## Appeal Decision

**Appeal Ref: APP/T2350/W/15/3124801**

**Curtis House, Longridge Road, Longridge, Lancs PR3 2NB.**

- The appeal is made under section 78 of the Town and Country Planning Act 1990 against a refusal to grant planning permission.
  - The appeal is made by NRS Contracts Ltd against the decision of Ribble Valley Borough Council.
  - The application Ref 3/2015/0272, dated 6 March 2015, was refused by notice dated 12 May 2015.
  - The development proposed is erection of detached double garage.
-

PROPOSED SITE PLAN

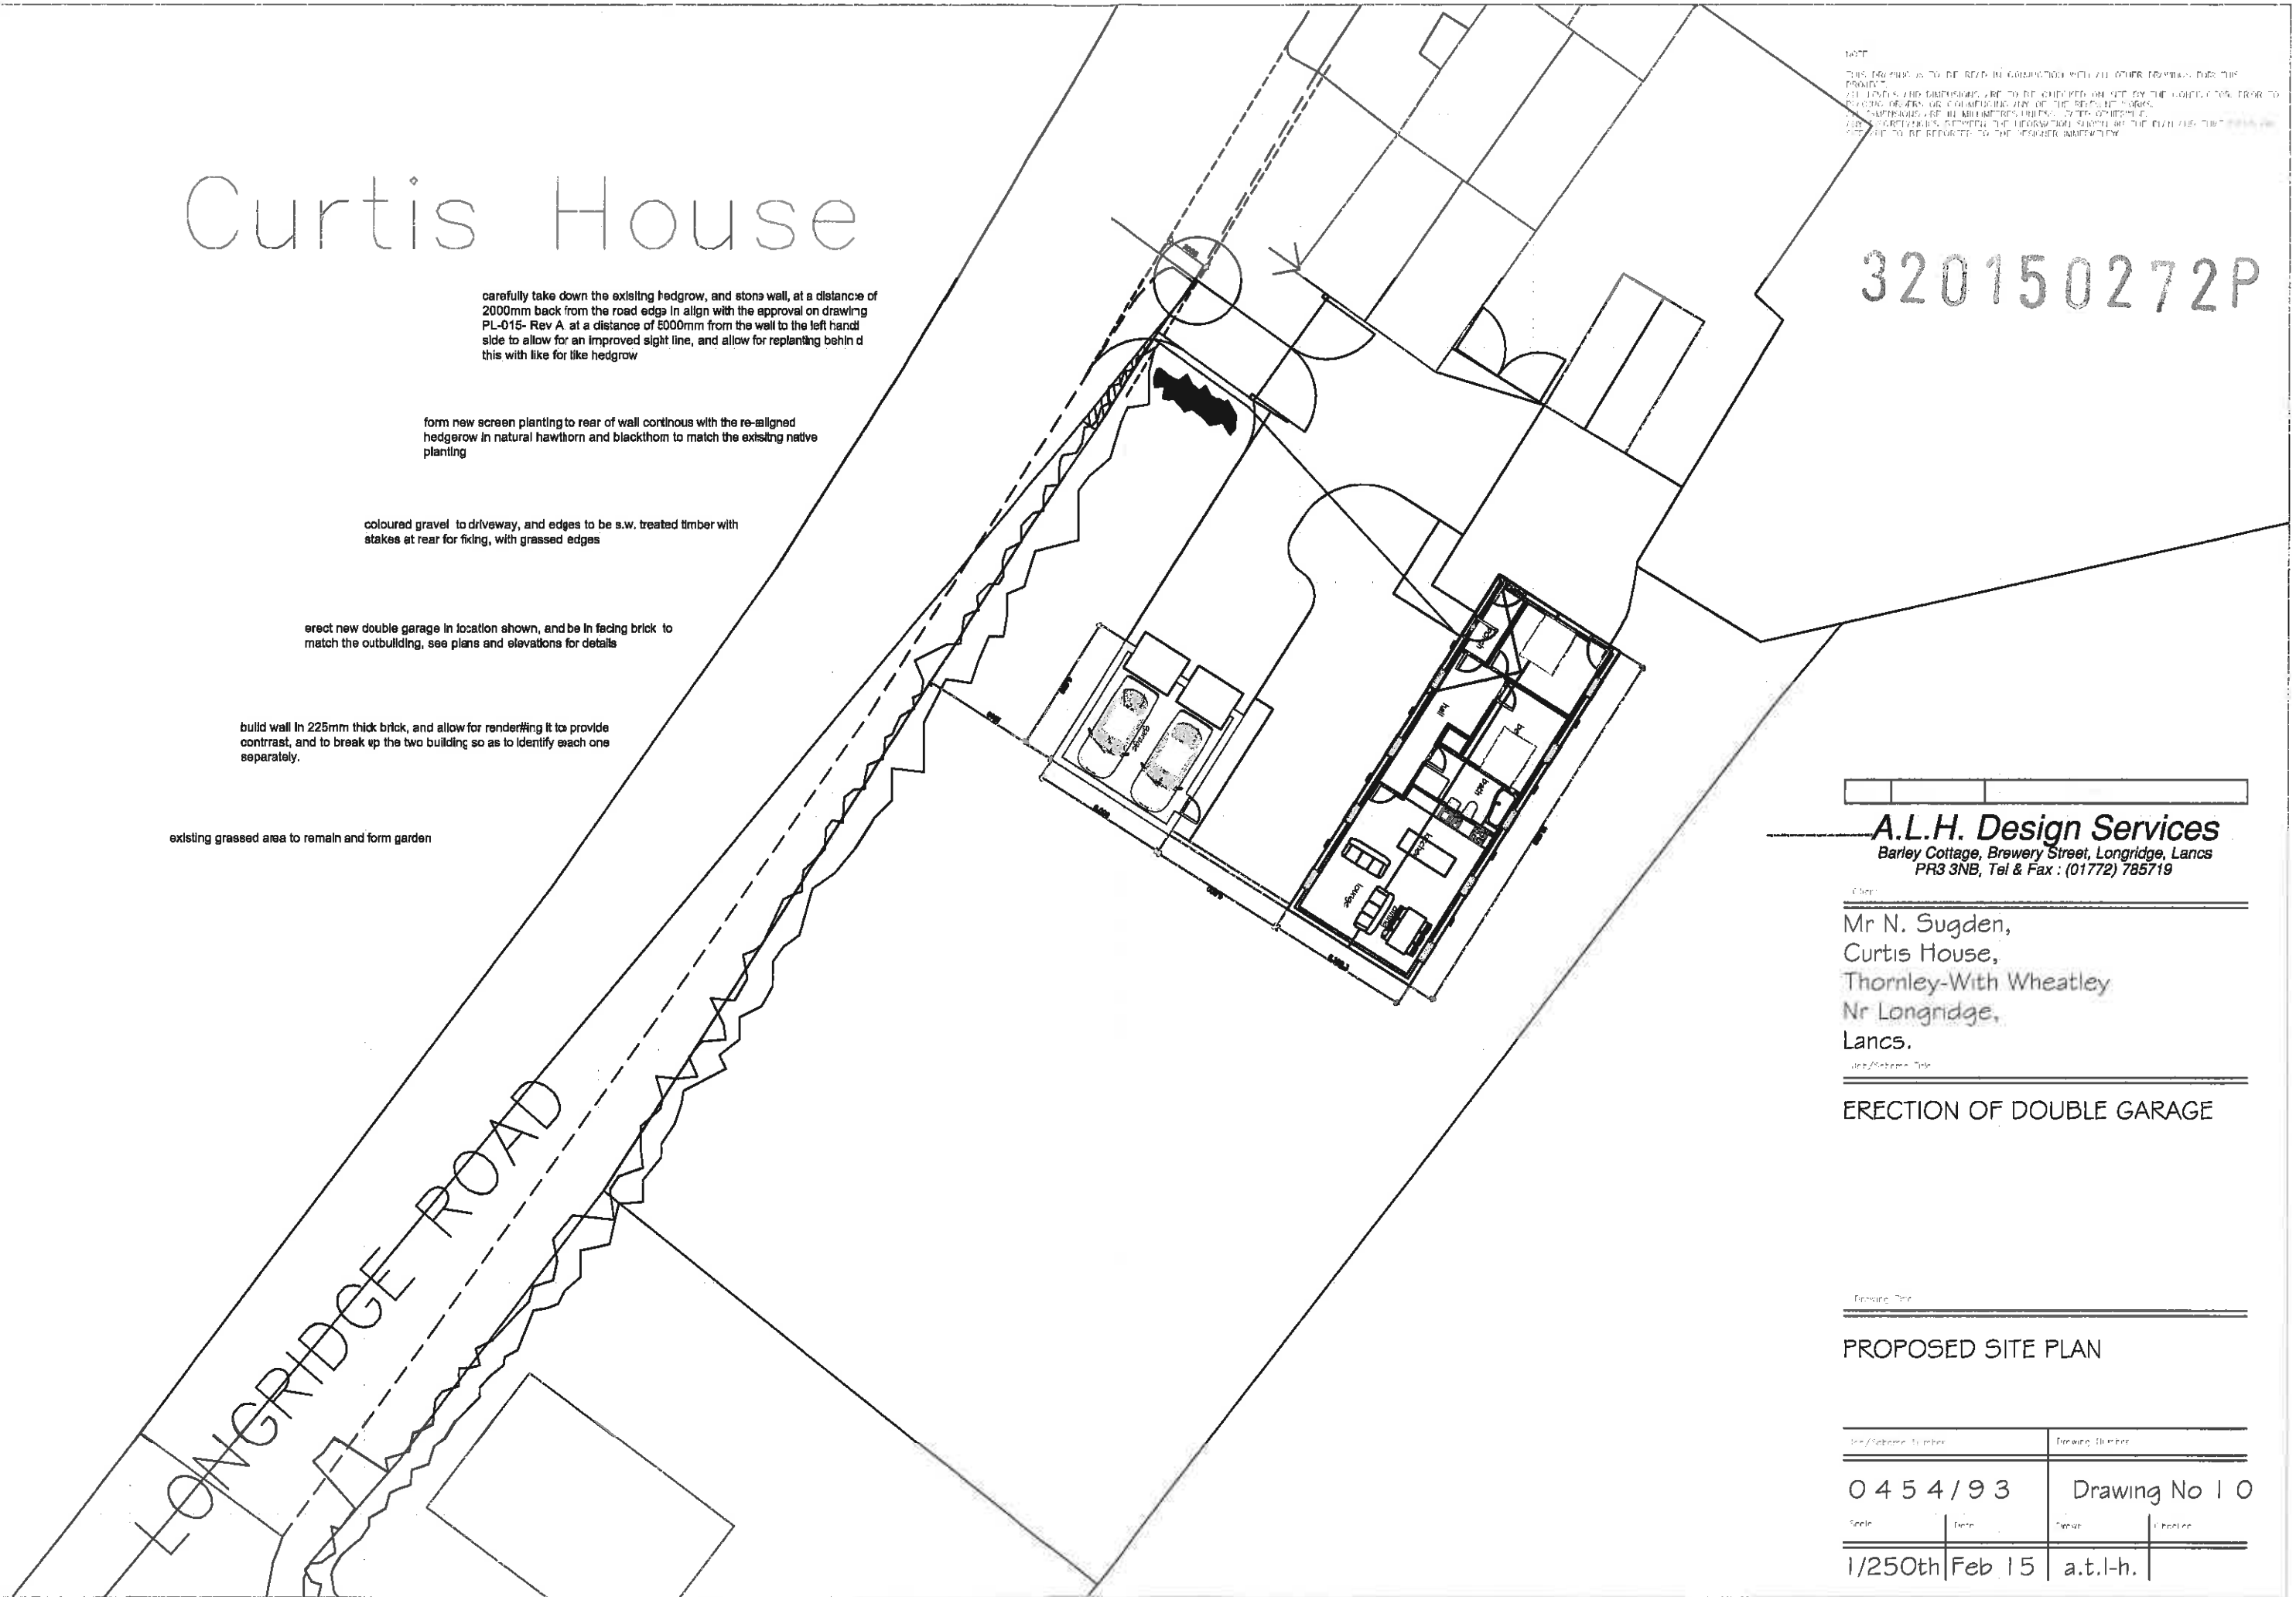
9. The proposed garaging would be joined to the host building at its southernmost end by a rendered breeze block wall of around 1.8 metres high which would extend for around 6 metres. Together, the rear of the wall and the side elevations of the garage and shippon would run almost the whole depth of the paddock.

10. Consequently, the open rural aspect of the site and its setting would be compromised as a result of the introduction of a tall wall and a double garage whose ridge line would dominate, partially obscure, and alter the rural appearance of the former shippon.

13. I understand that the appellant wishes to provide garaging on the site and that as a result of allowing the conversion of the agricultural building that the nature of the appeal site will inevitably change. However, the wall, together with the marked driveway, coloured gravel, and the construction of a large double garage would introduce a suburban ambience into an important landscape and impact on the setting of the AONB.

PROPOSED GARAGE ELEVATIONS
 (Streetscene)

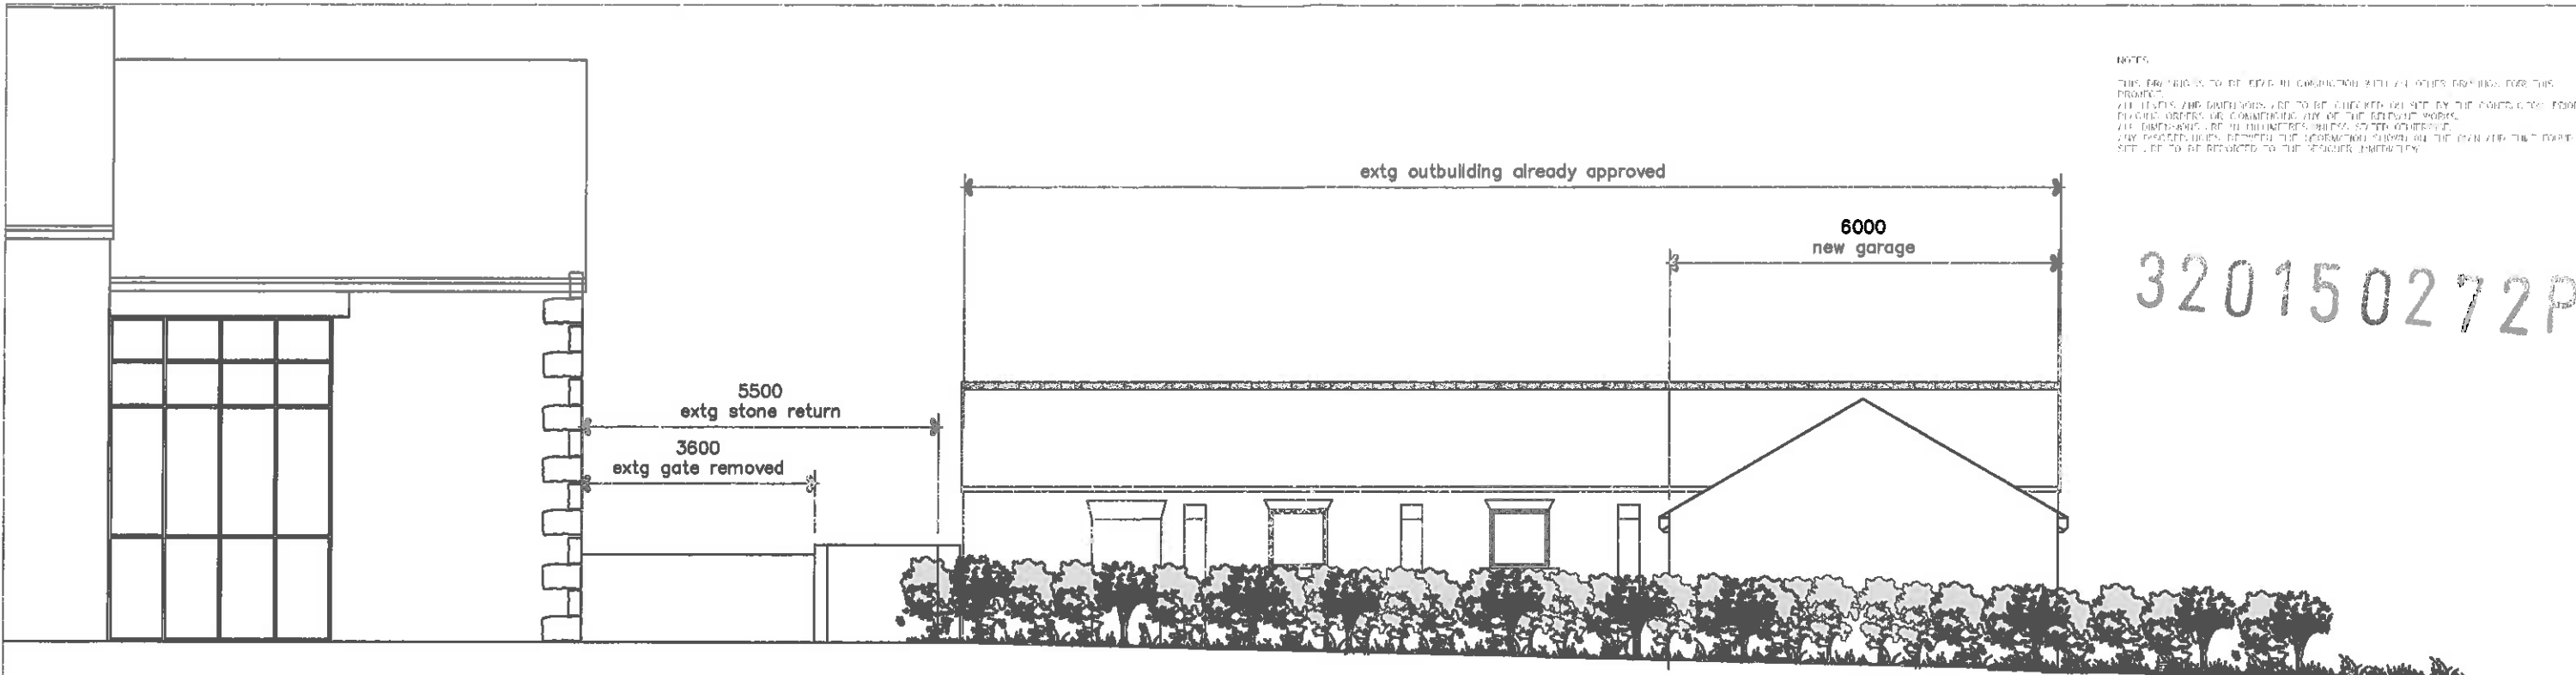
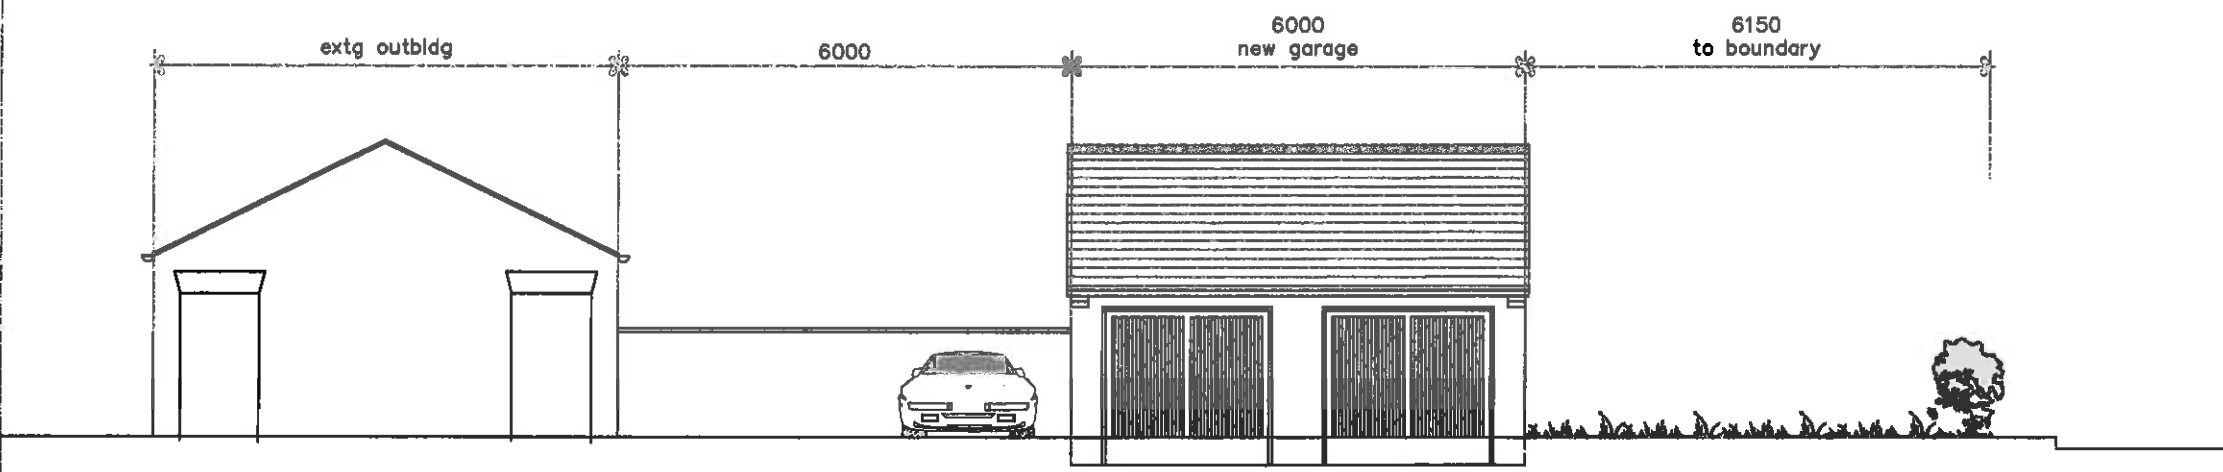
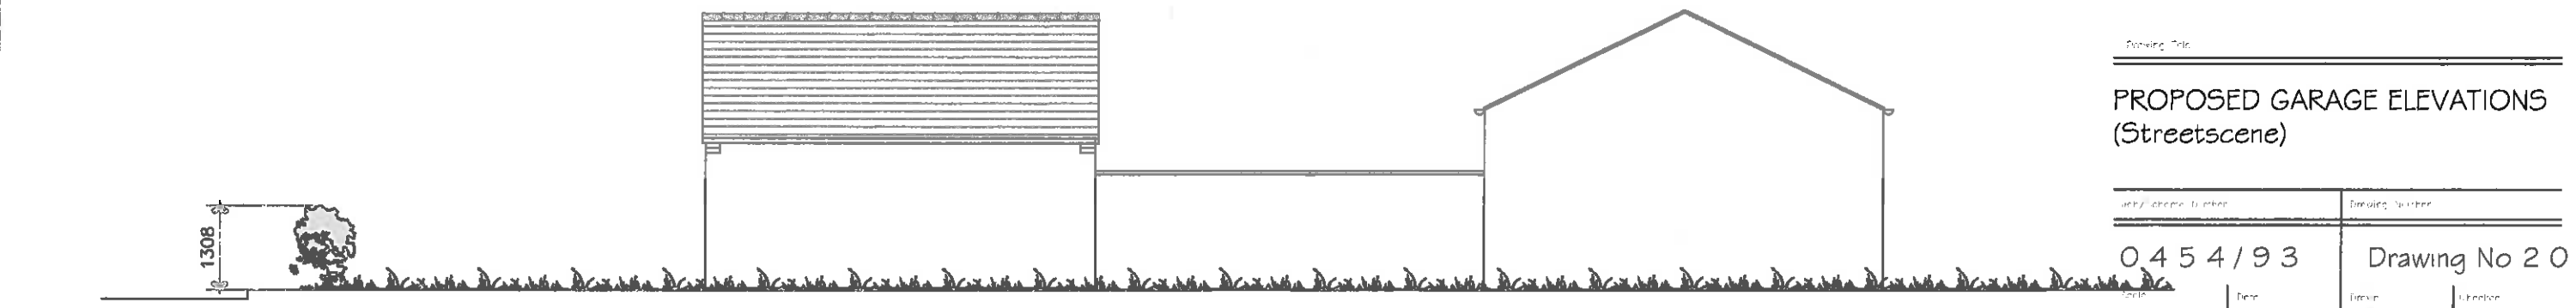
11. The existing hawthorn hedging which forms the boundary to the road is of modest height. Consequently, there are open views into the site. When viewed from the public footpath to the south of the appeal site the proposed development would be less visible. This would be as a result of the partial screening by the Pumping Station and in the summer, the tall thick hawthorn hedge. In the winter this would be less effective. However, the rendered wall, juxtaposed with the brick garages and shippon would be most visible when viewed from Longridge Road travelling towards Chipping and the AONB and would be seen as a large obtrusive feature in the landscape.
